Subject: Re: R/62/20/HH - Smugglers - Garage

From: Mark Warwick <Mark.Warwick@arun.gov.uk>
Sent: 22 July 2020 17:36
To: 'David Fuller' [REDACTED]
Cc: Zac Denton <Zac.Denton@arun.gov.uk>; Juan Baeza <Juan.Baeza@arun.gov.uk>
Subject: R/62/20/HH

Planning Officer:	Mr Z Denton
Planning Application Ref:	R/62/20/HH
Location:	Smugglers, 4 Botany Close, Rustington, BN16 2BH
Description of works:	Erection of detached garage
Comments on Application:

Drawing Name
Plans, Elevations, Roof Plan and Block Plan
Garage -
Proposed

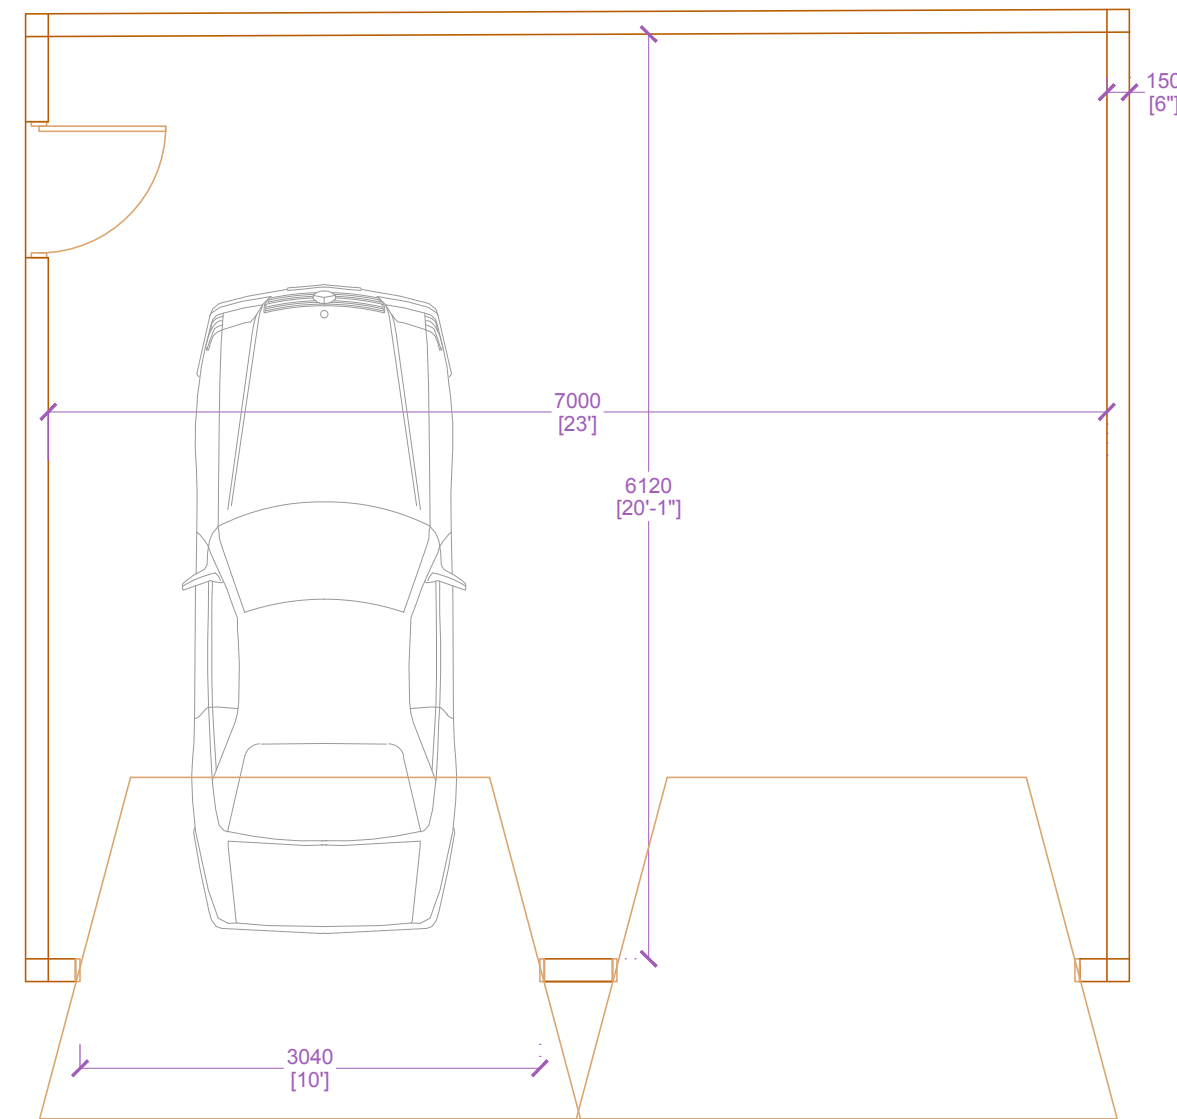
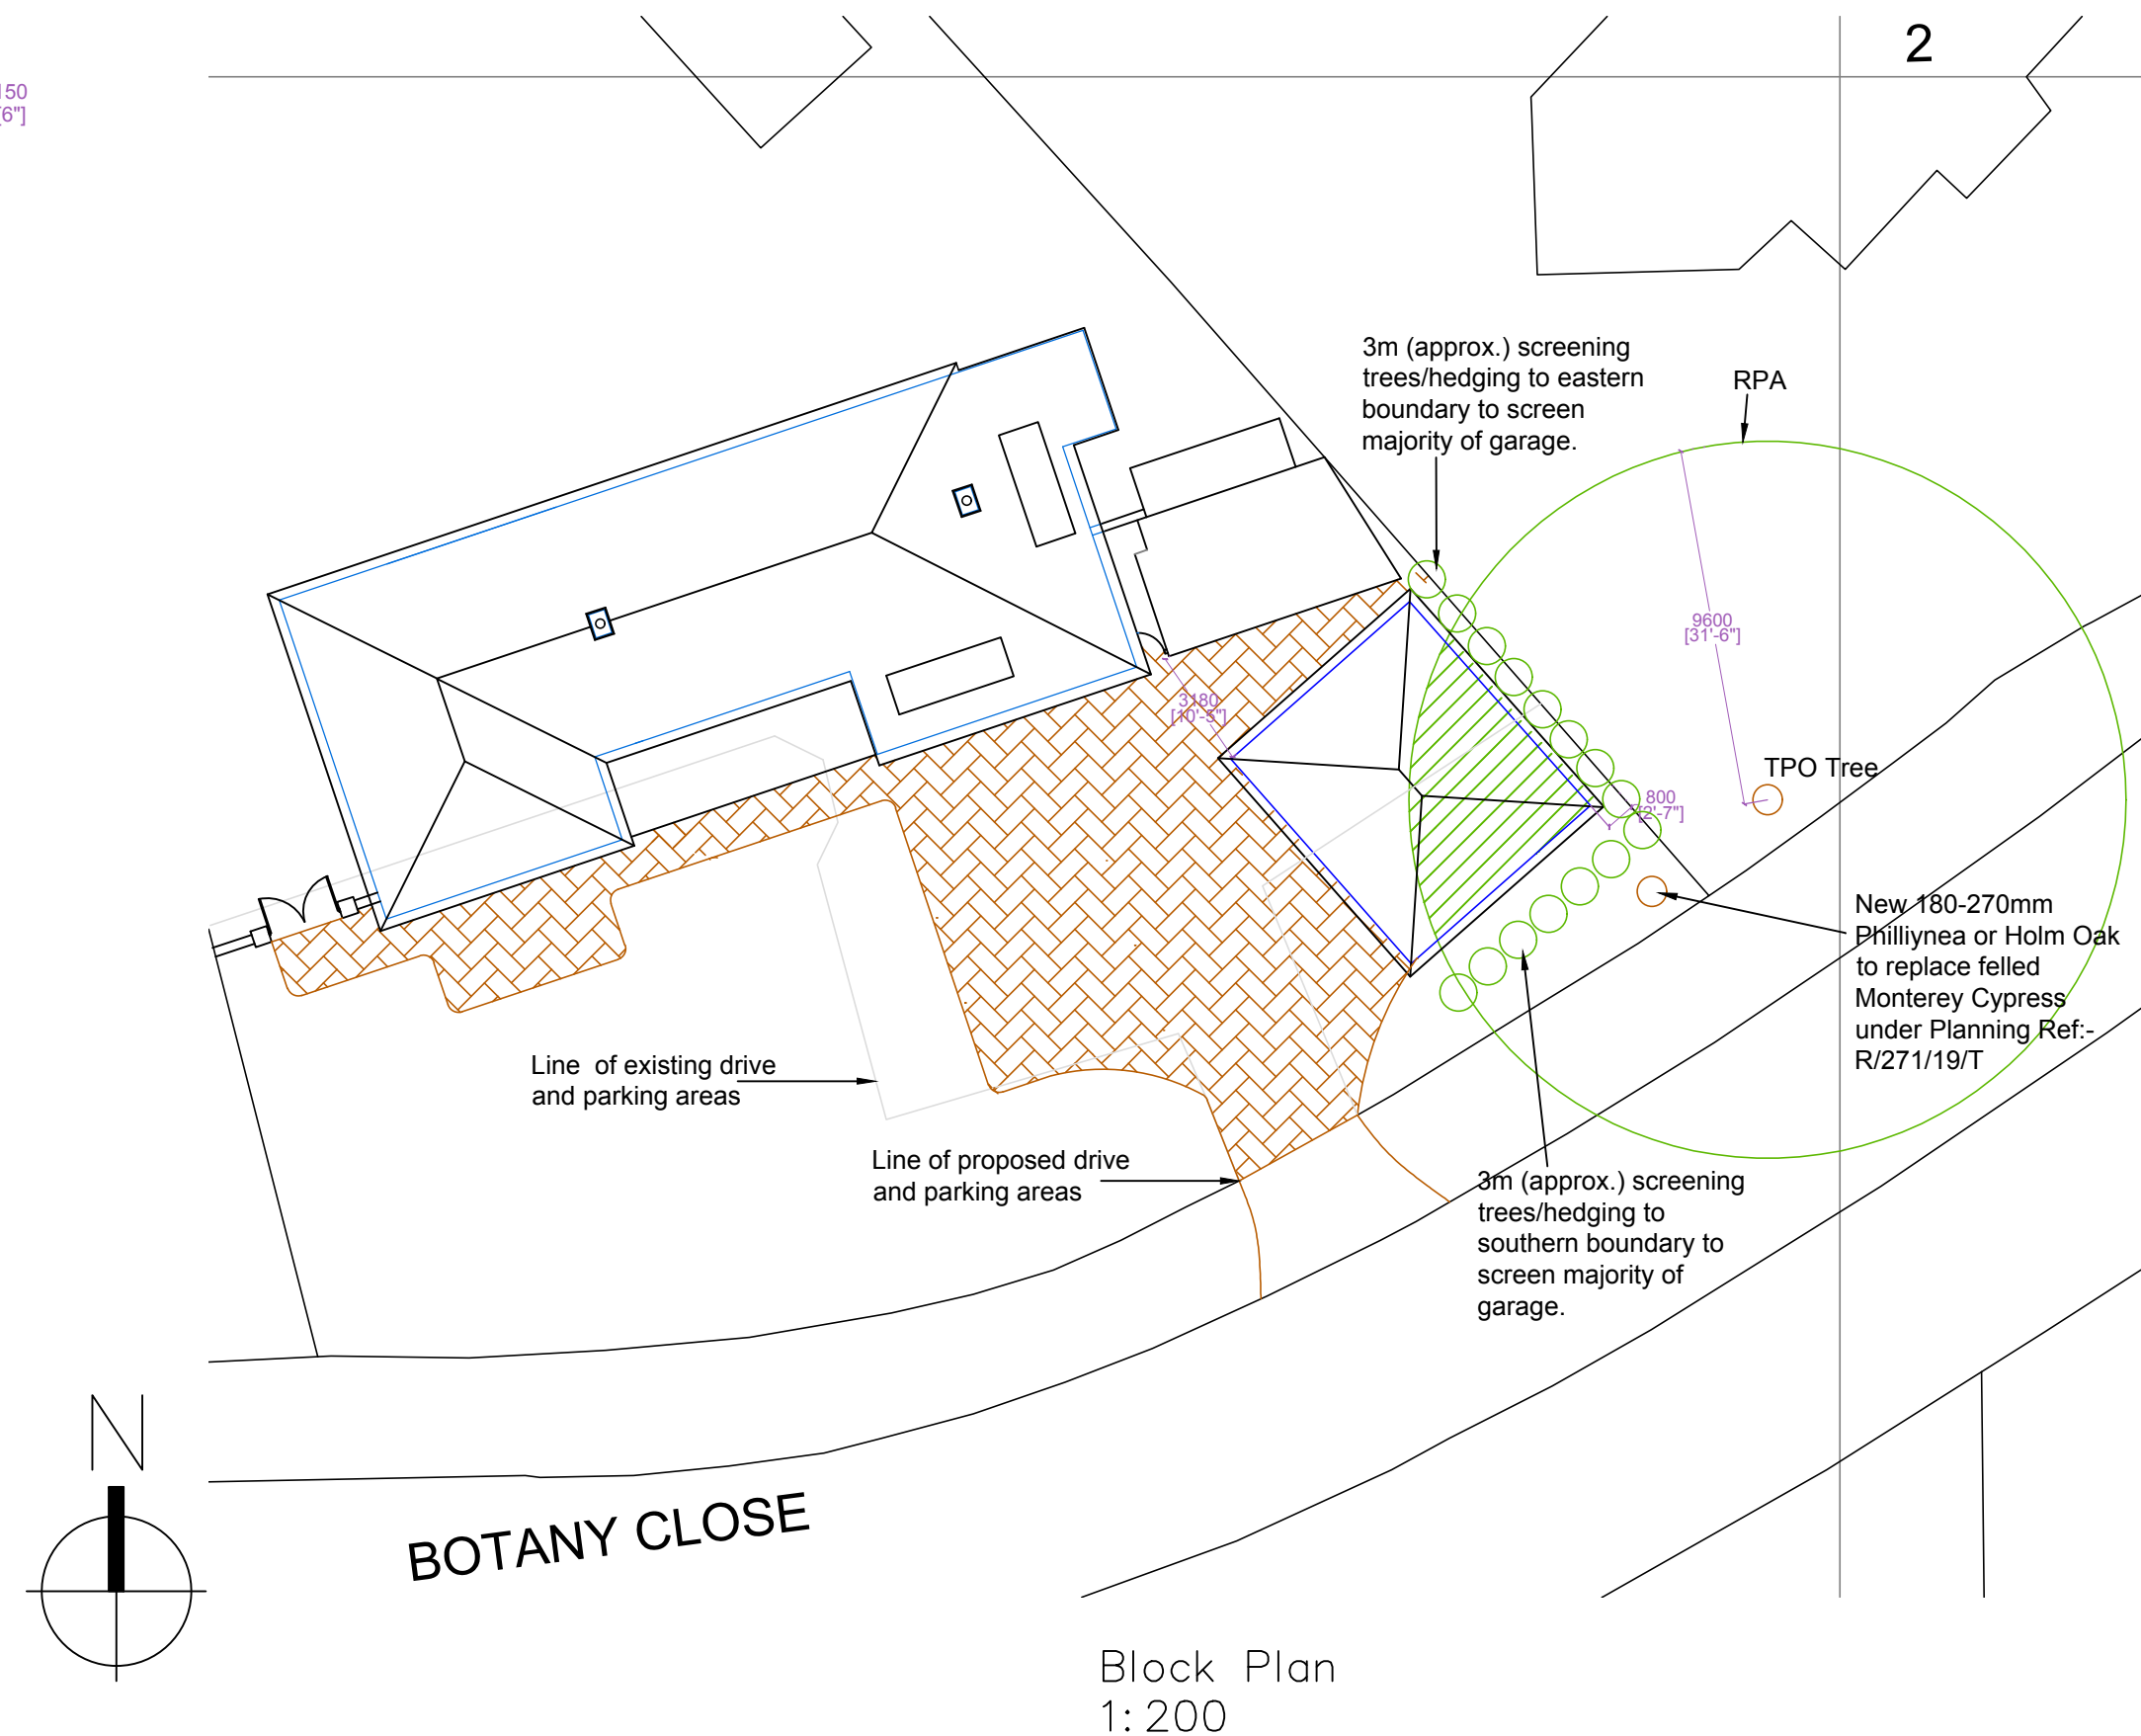
- Notable but tolerable incursion into that tree's Root Protection Area (RPA) is proposed. As such, BS5837:2012 recommends we have an Arboricultural Method Statement (AMS) and also most importantly a Tree Protection Plan (TPP) – to both describe and illustrate the mitigation measures which are to be employed. A briefing note cannot satisfy that requirement.

- The following items will need to be addressed in detail within the above AMS and TPP:
 - RPA overlapping site and beyond footprint of proposed structure to be fenced off to prevent access, storage of materials, contamination risk/compaction.

- Method of excavation and treatment of exposed roots within excavation. Watching brief may be necessary, especially if structurally important roots are uncovered.

- Membrane to prevent curing concrete coming into direct contact with exposed/cut root material.
 - Soft landscape proposals - duty to replant with specimen tree as per R/271/19/T, within RPA. How will the garage structure tolerate a tree of high growth potential in

such proximity? Should an alternative front garden location be considered for feature tree planting (*Phyllirea latifolia* or *Quercus ilex*)? Please confirm.
